Tel: 01895 250230
Case Officer: James Wells
Email: JWells@hillingdon.gov.uk
Date: 11th October 2021
Our Ref: 76590/PRC/2021/160

RE: New dwelling

SITE: Land Adj To 2a North Hyde Road Hayes

Plan Numbers: Pre app plans & elevations - 100 - received 13 Jul 2021

## 2 Site Plan

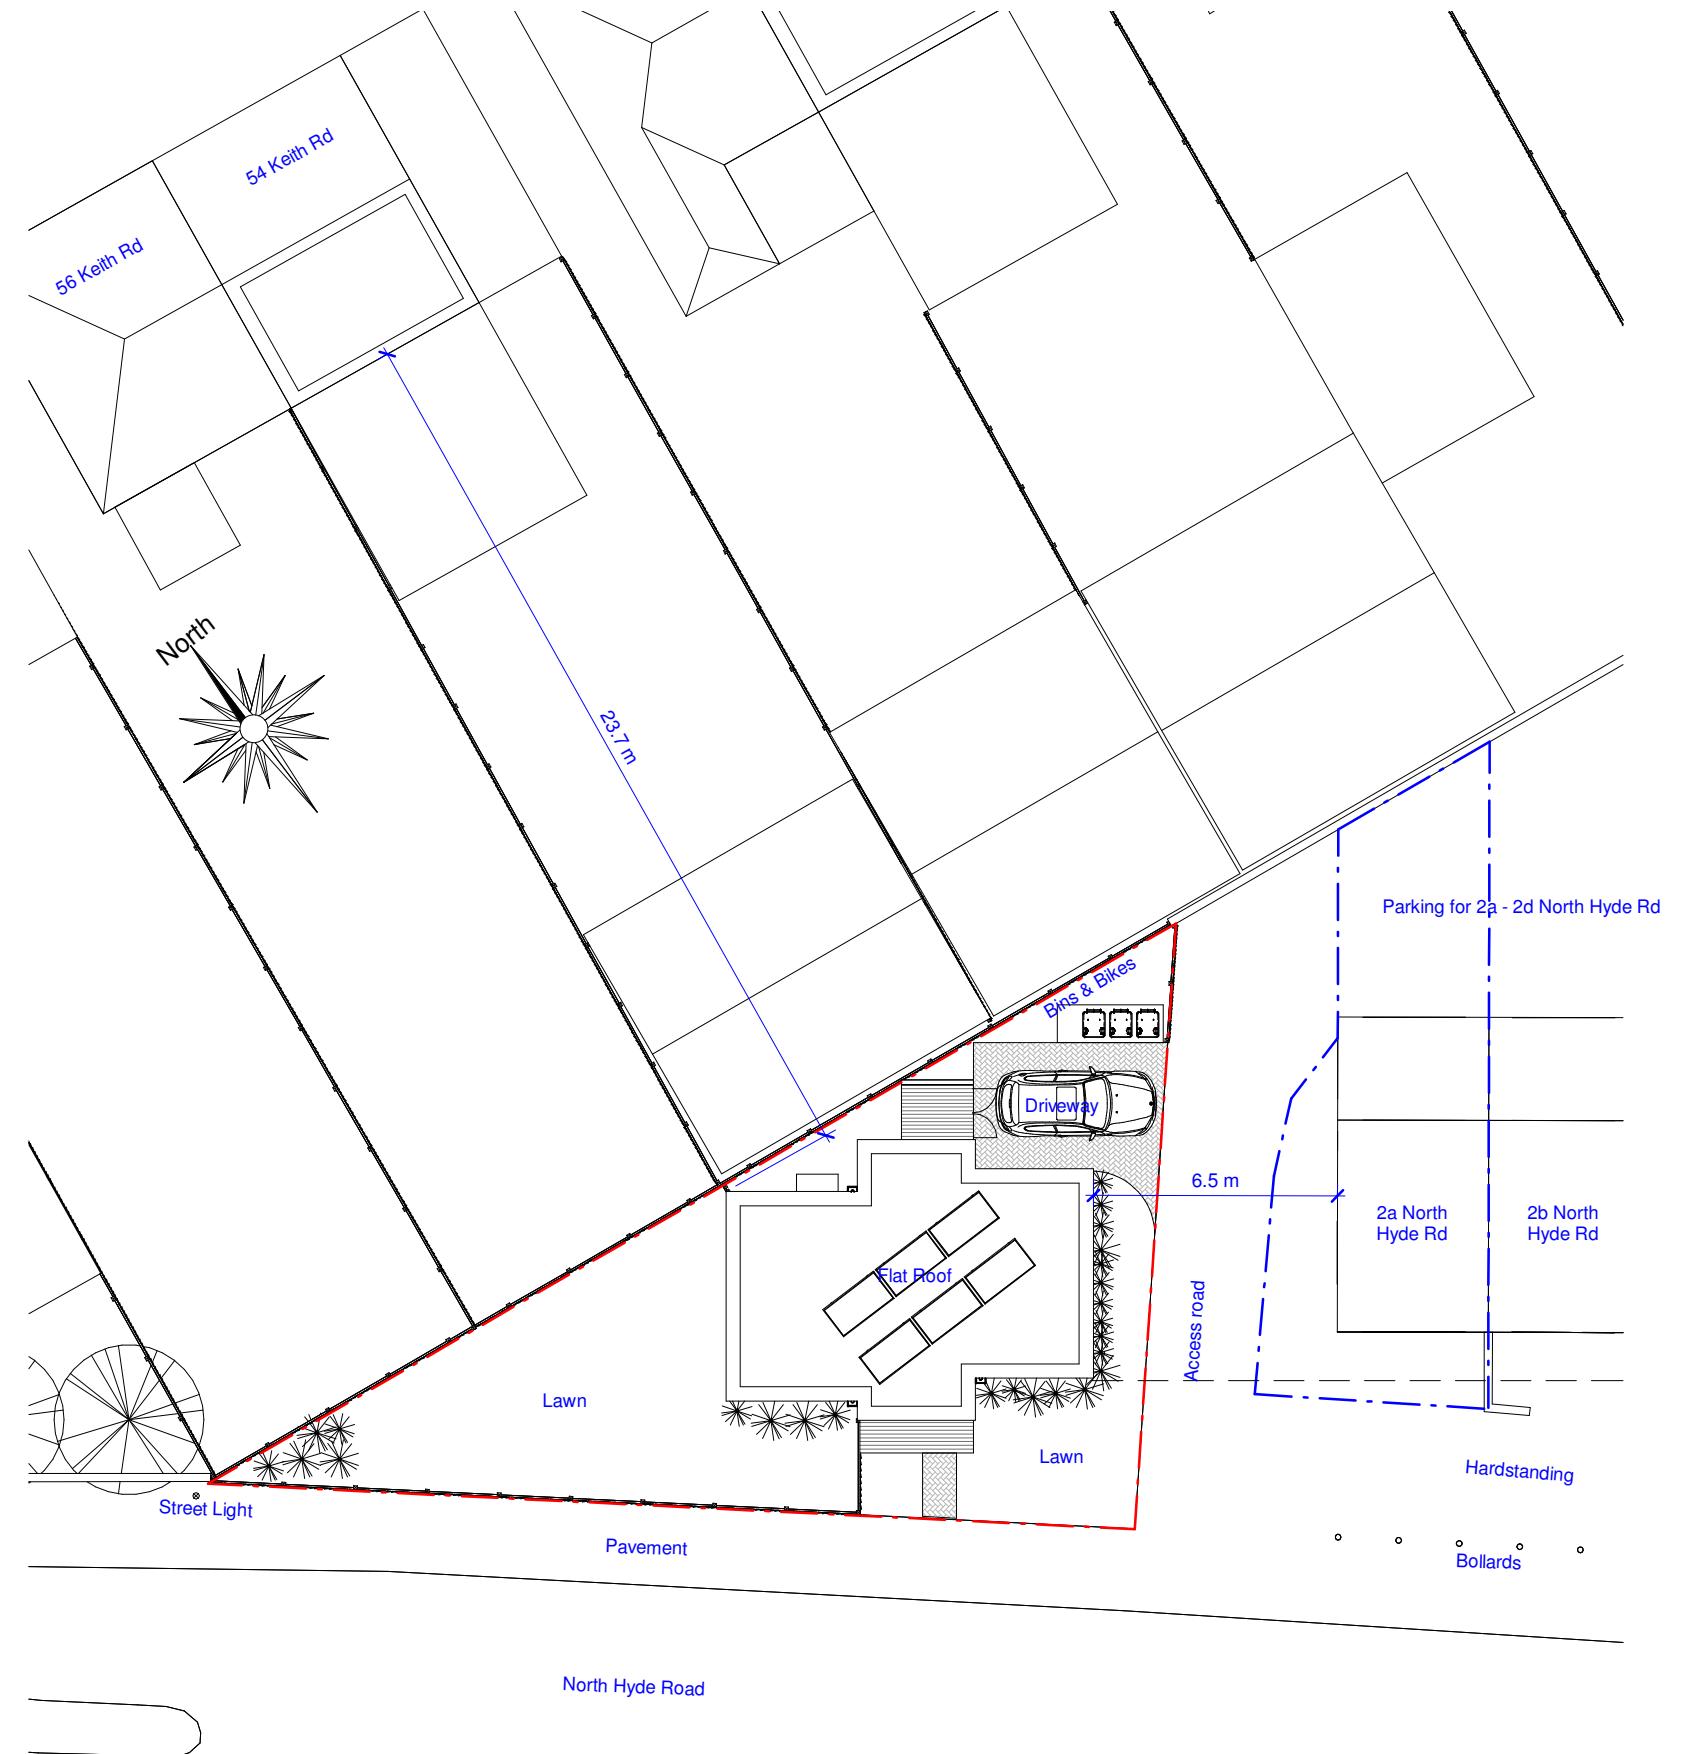
The applicant is proposing one on-site car parking space arranged parallel with the highway given the red line boundary and it would appear cycle parking for 3 cycles at the rear of the site are to be provided.

Parallel parking to the carriageway shall not be permitted, the layout of the parallel car parking bay is substandard and the vehicle access for the proposed parking bay is opposite the bus stop cage which under normal circumstances approval will not be given to dropped kerbs within the lines of a bus cage; see policy and guidance below:

The applicant has shown 3 cycle parking spaces at the rear. The cycle parking should be in a secure and sheltered storage, the applicant is required to demonstrate that the layout and dimensions of the cycle storage is in accordance with policy DMT6.

1 Front / SW Elevation
1 : 100

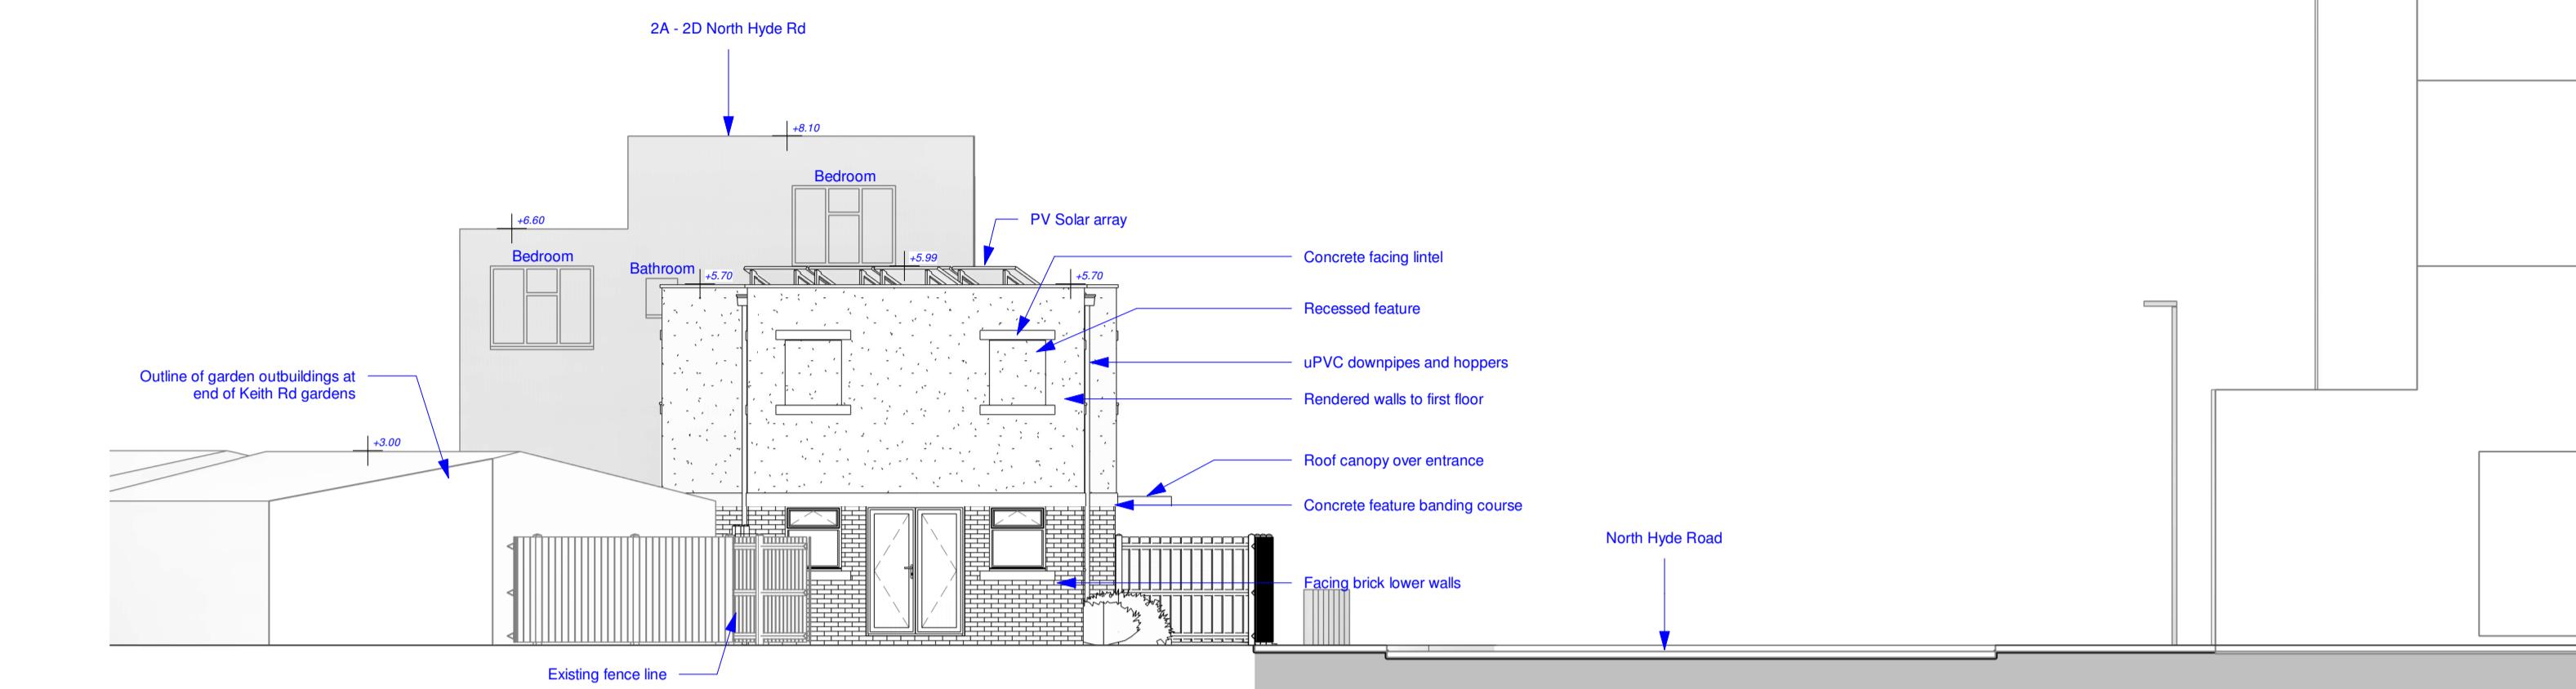
First floor windows are proposed, including one in the front elevation that is likely to cause overlooking and loss of privacy to the existing properties in North Hyde Road. The proposed dwelling is also likely to cause loss of light and adversely affect the outlook of the existing properties in North Hyde Road. One on-site car parking space is proposed, sited parallel with North Hyde Road. The Highways Officer advises that parallel parking to the carriageway shall not be permitted and the layout of the car parking space is substandard. However, given the sites good PTAL rating of 4 and local parking restrictions, a car free development may be acceptable to the Council. The proposed development is more intimate in mass and scale and lower than the existing adjacent dwellings. No trees, shrubs and wildlife habitat are retained or re-provided.

The submitted plans indicate that the proposed detached dwelling would be sited only approximately 6 metres west of the existing dwelling at 2A North Hyde Road. The first floor window in the front / south-west elevation of the proposed dwelling would cause unacceptable overlooking and loss of privacy to the existing dwelling at 2A North Hyde Road and the position of the building, relative to adjacent windows is likely to cause loss of light and adversely affect the outlook of residents at 2A North Hyde Road, contrary to the amenity requirements of Policy DMHB 11.

The submitted plans indicate that the proposed detached dwelling would be sited only approximately 6 metres west of the existing dwelling at 2A North Hyde Road. The first floor window in the front / south-west elevation of the proposed dwelling would cause unacceptable overlooking and loss of privacy to the existing dwelling at 2A North Hyde Road
